CHATBURN PARISH COUNCIL

Planning Application No. 3/2021/0657 - 10 Sawley Road

Chatburn Parish Council has viewed the above planning application and has the following observation to make.

NO#		REVISION		DATE	PROJECT NAME: APHRODITE SLIDING GATE
DRWN BY	I.SINGLETON	NAME	DATE		CUSTOMER: JOE BUTLER
CHKD BY			16/04/2021		DRAWING NO:
APPD BY

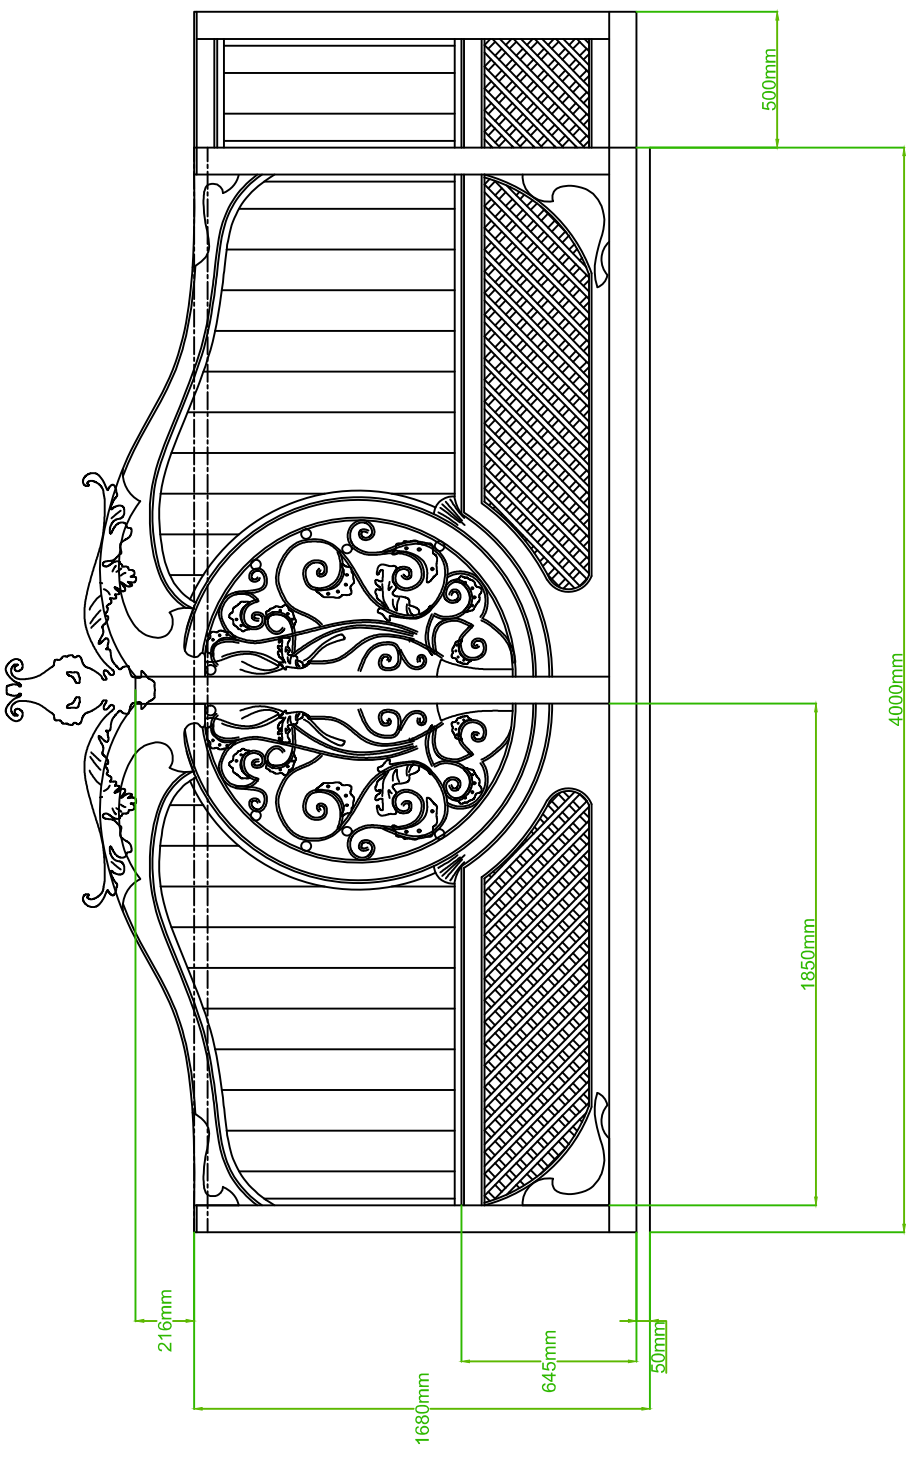
The proposed gates do not appear to be in sympathy with Grade 11 listed church (opposite) and gates in close proximity to the property.
